Our Reference: SYD15/01506/04 (A17744288)
DP&E Ref: SSD 7401

**PROPOSED RESOURCE RECOVERY FACILITY
24 DAVIS ROAD, WETHERIL PARK**

Reference is made to the Department of Planning and Environment (DP&E) letter dated 28 April 2017, regarding the abovementioned application which was referred to Roads and Maritime Services (Roads and Maritime) for comment.

PROJECT	PROPOSED GREENSPOT RESOURCE RECOVERY AND RECYCLING FACILITY 24 DAVIS ROAD WETHERILL PARK NSW 2164	PROJECT NO.	1521
CLIENT	BETTERGROW	SCALE	1:200
TITLE	ORGANICS RECEIVAL AND PROCESS BUILDING SITE PLAN	JOB NO.	0604-16
		SHEET NO.	A02
		ISSUE	C

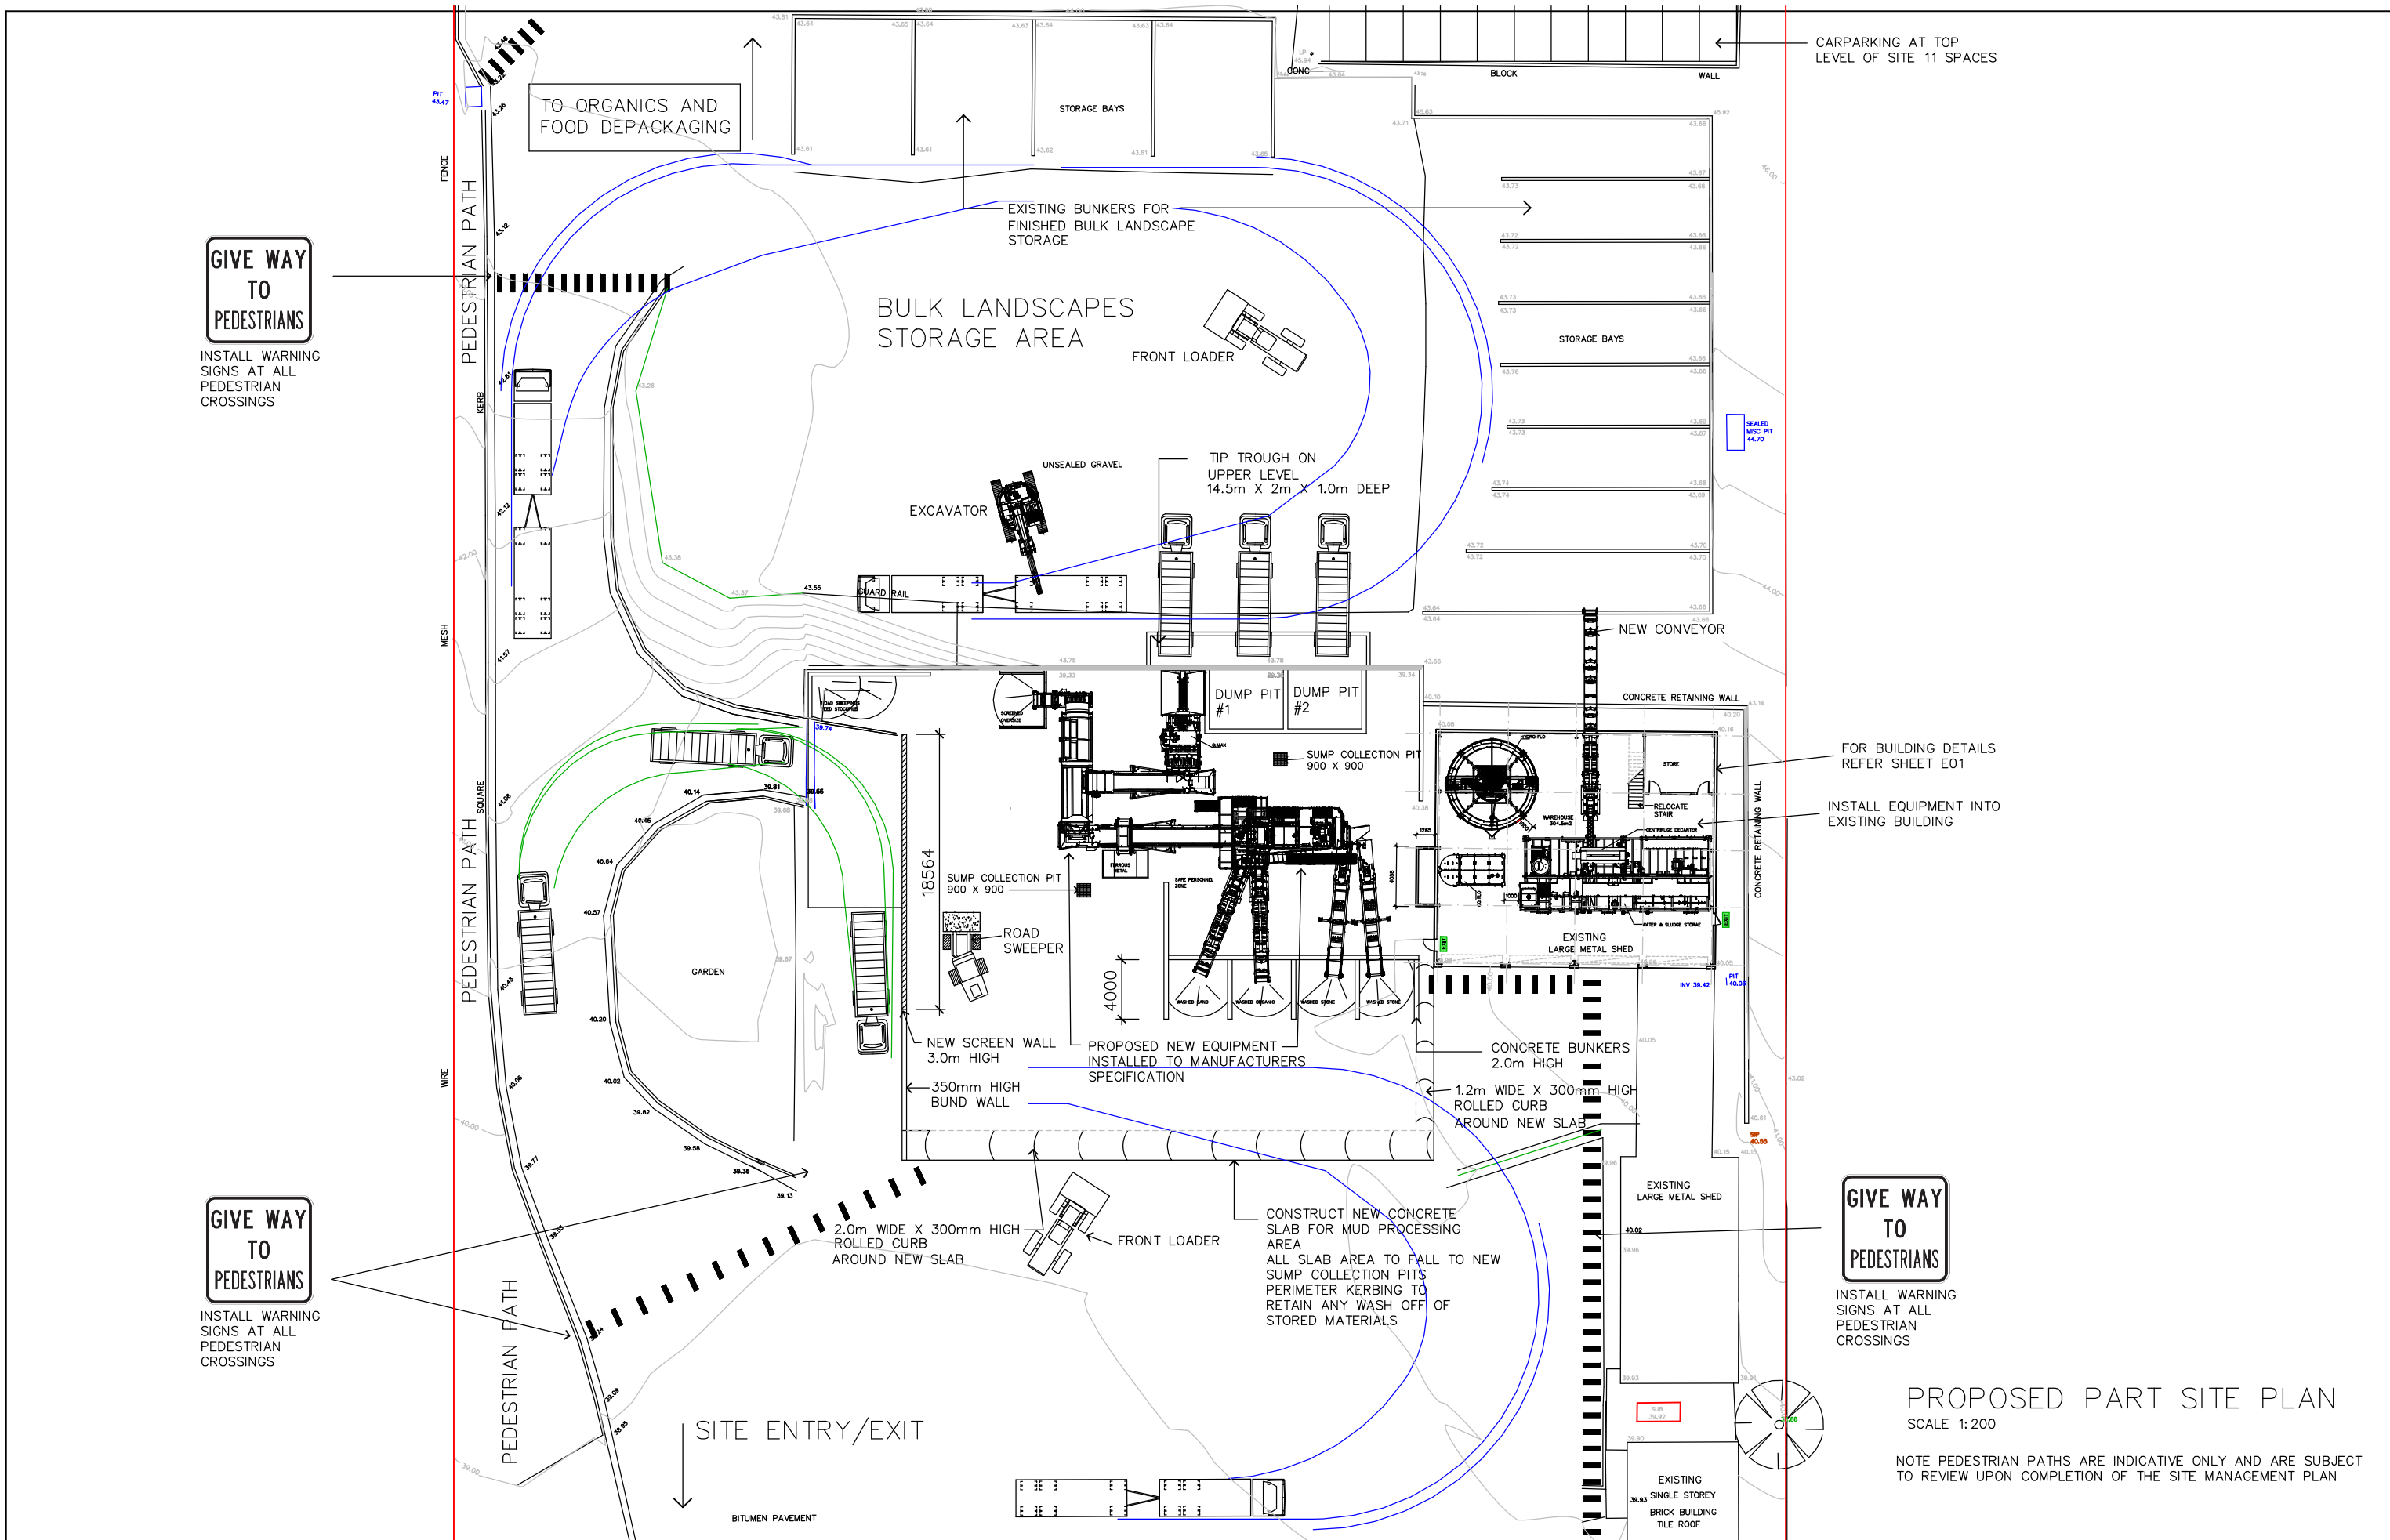
1. All vehicles are to enter and exit the site in a forward direction. Provision for vehicles to turn around must be provided within the property boundary.
2. Car parking should be provided to Council's satisfaction.
3. All works/regulatory signposting associated with the proposed development are to be at no cost to Roads and Maritime.
